# PLANNING AMENDMENT

Description: Erection of garage and summer house

Location: Linden House  
Church Gate  
Gedney

Amendment: Roof-lights added to garage  
Dwg.No.0208-02 & details of Roof-light

DETERMINED  
PLAN

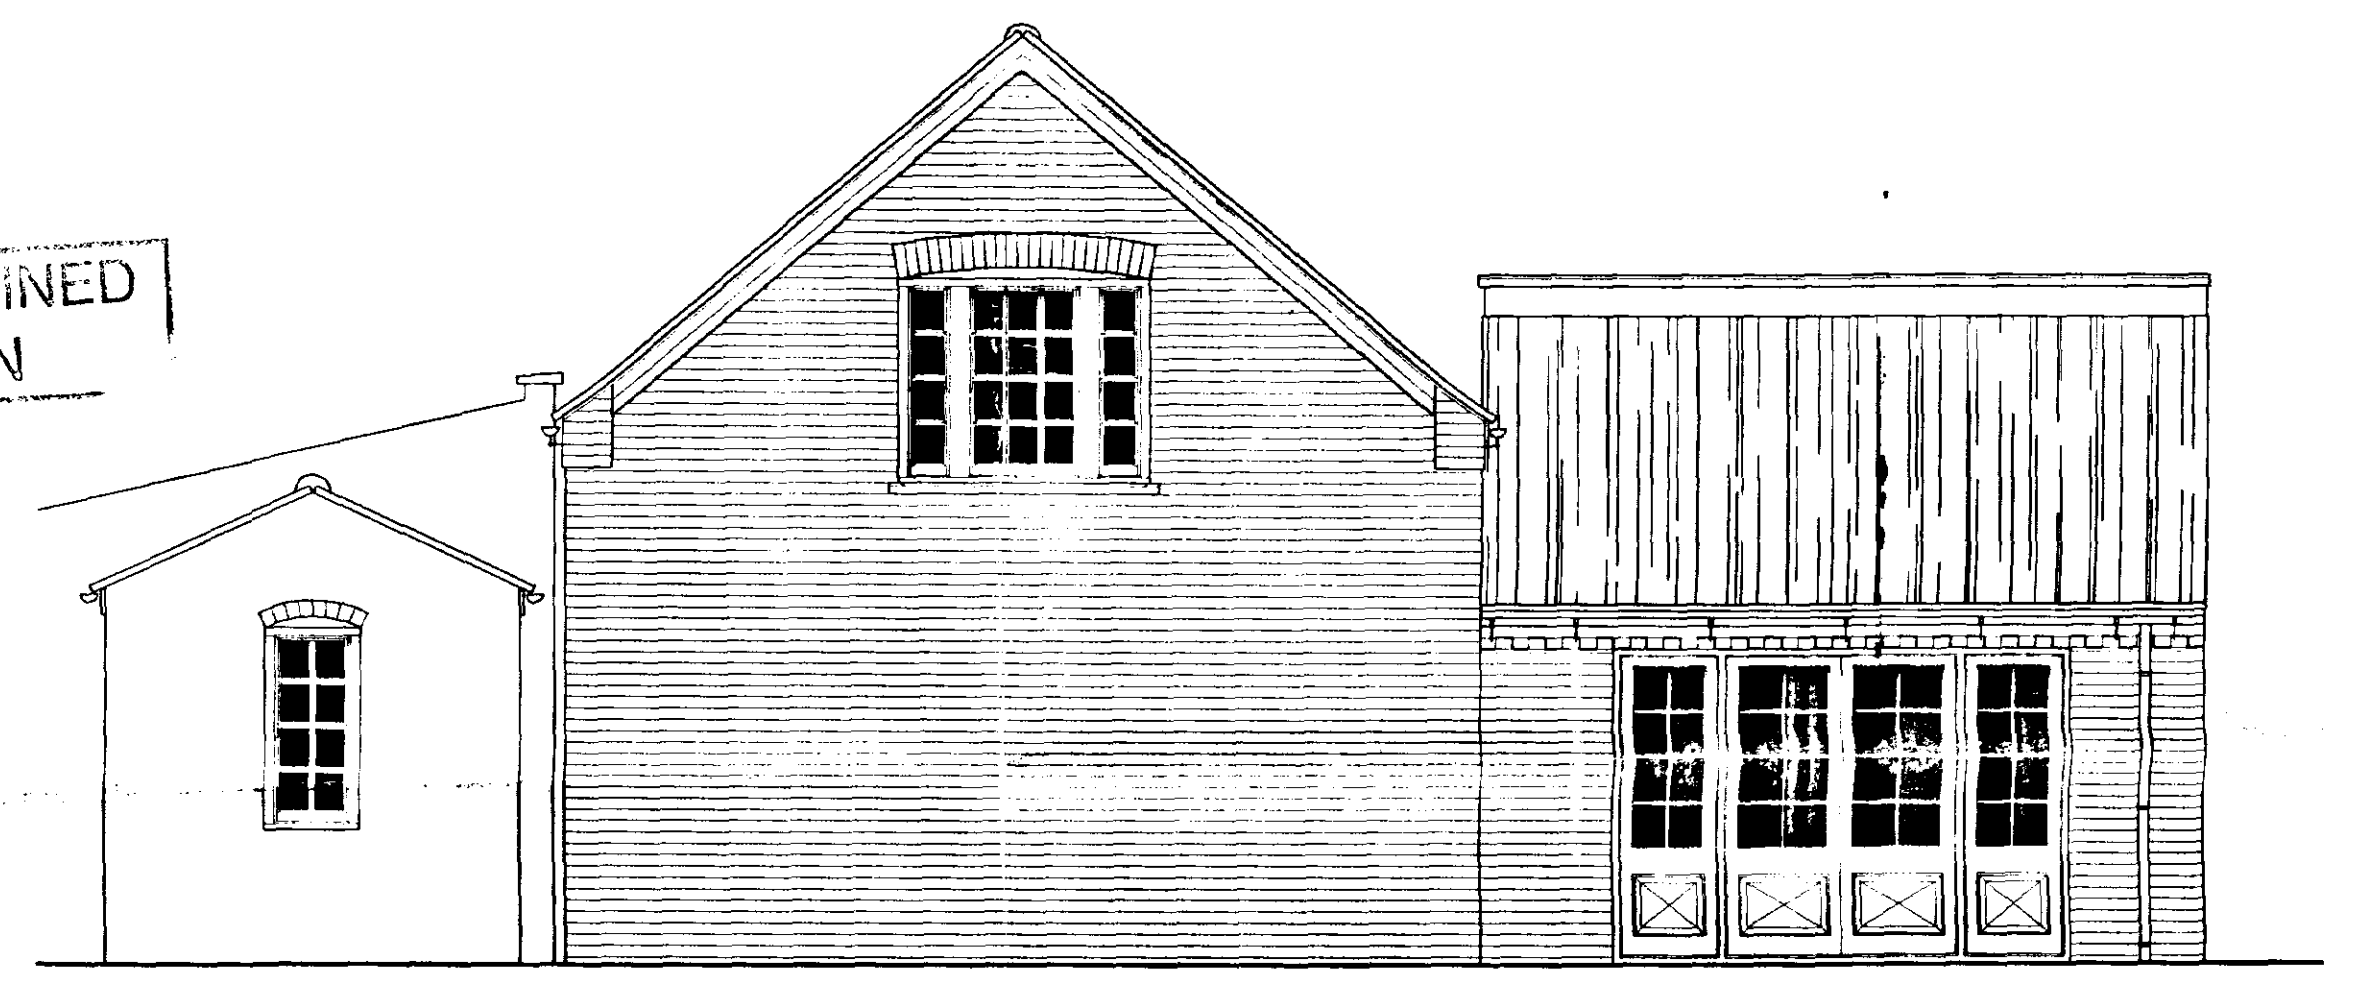
ROOF LIGHTS ADDED TO GARAGE
